**Subject: EnergyConnect (NSW - Western Section) – SSI 10040**

Thank you for your email dated 27 October 2020 seeking comments from the Biodiversity and Conservation Division (BCD) of the Department of Planning, Industry and Environment (the Department) on the Environmental Impact Statement (EIS) for the EnergyConnect (Western Section) project (SSI 10040).

## ATTACHMENT A BCD Assessment Summary for EnergyConnect (NSW – Western Section) Environmental Impact Statement (SSD 10040)

## **ATTACHMENT B Detailed comments for EnergyConnect (NSW - Western Section) Environmental Impact Statement (SSI 10040)**

220kV transmission line easement between Buronga substation and NSW/Victoria border

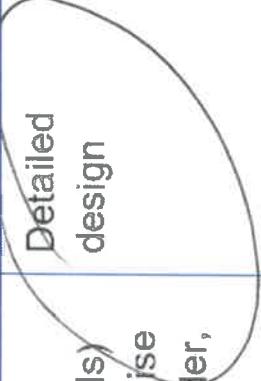
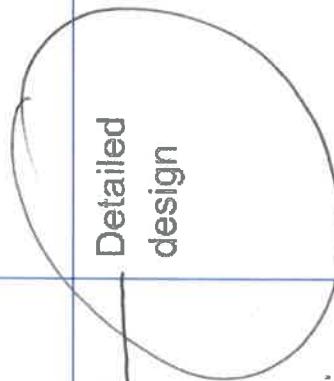
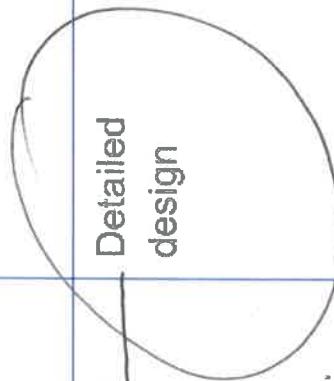
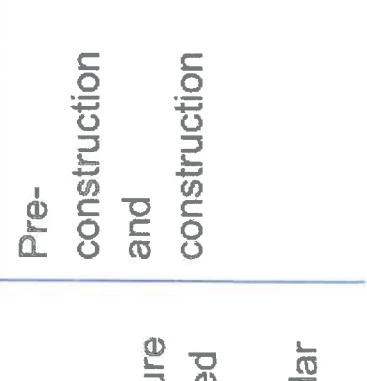
The EIS states that impacts have been, or will be, reduced as 'far as possible', but the EIS does not state the reasons why the transmission line easement needs to be up to 80m wide (Section 5.5.2 and Figure 5.9 EIS). Clearing is the greatest impact of the project and this is a construction standard that does not take into account the site context, including the typical height of canopy trees.

A TransGrid Line Design Standard (July 2018) which complies with AS/NZS 7000 standard states that easement widths are 'sized to ensure standard safety clearances under high wind conditions, provide an area where vegetation heights can be controlled and provide ease of access for ongoing maintenance and repairs'. The standard width for 300kV single or double circuit is 60m.

The easement width in this project does not consider the nature of the vegetation communities through which the transmission line passes. The same easement that will be applied in this project in the very low, open woodland of western NSW is used in the tall closed forest in eastern Australia, where risks from high winds and fire are likely to be greater. If the easement width is designed to manage risks to infrastructure then additional justification is required

- *Provide reasons for the need for a standard Transgrid easement width that relate specifically to the low and sparse natural vegetation communities of western NSW.*

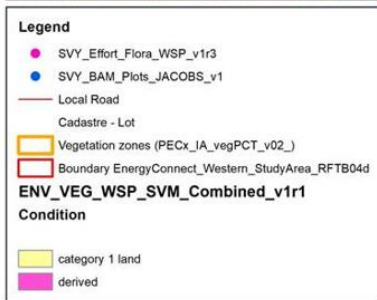
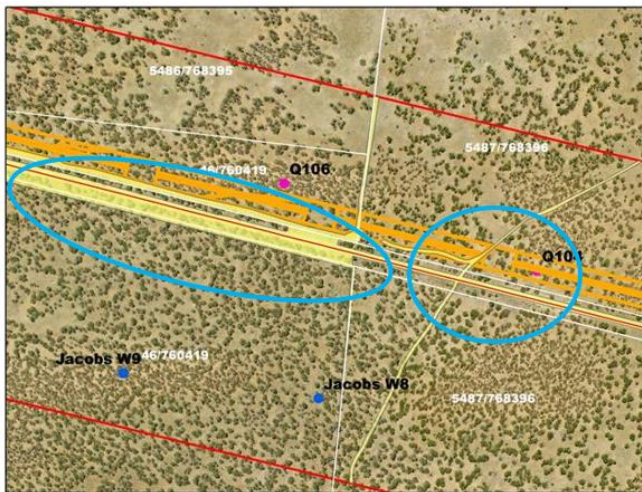
Areas of vegetation labelled as 'no impact' in the digital data (PECx\_IA\_vegPVT\_v02) where maintenance activities may occur have not been assessed.

Some areas of naturally treeless vegetation have not been assessed. Assumptions about the impact of maintenance on biodiversity are not sufficiently explained to justify exclusion of these areas from the assessment.

For example: South Olary Plain sub-region (Lot 9, DP 1255309), mapped as PCT 154 Pearl Bluebush low open-shrubland in the vicinity of Jacobs flora plot W12. Jacobs ecologists described vegetation within this plot as in 'good condition'.

- the specific impacts of maintenance
- if maintenance includes regular vehicle movements across the vegetation
- if weed control is to occur within this area, and if so, what are the impacts on this vegetation and associated threatened species and their habitats?

- *Include areas where maintenance actions will occur in the impact area for the project or justify why ongoing maintenance activities will have **no** impact on biodiversity.*

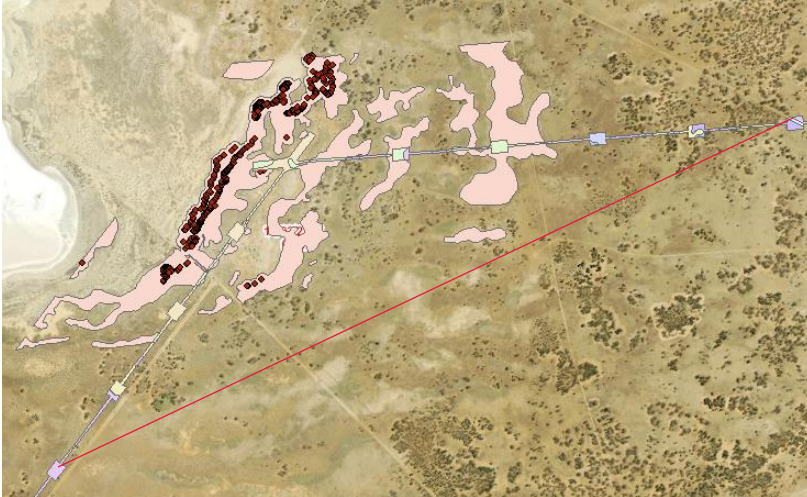
The project as presented avoids all impacts on *Dodonaea stenozyga*. The project will result in the loss of 2.18 ha of habitat for *Austrostipa nullanulla*.

However, the BDAR states that the proposal was refined to avoid and minimise impacts on *Austrostipa nullanulla*. In fact, there is an opportunity to completely avoid the gypseous rises that are habitat for this species by running the alignment south of this area (see figure below). The EIS does not explain why this option was not feasible.

- Explain why the project alignment cannot avoid the areas of habitat for *Austrostipa nullanulla*.
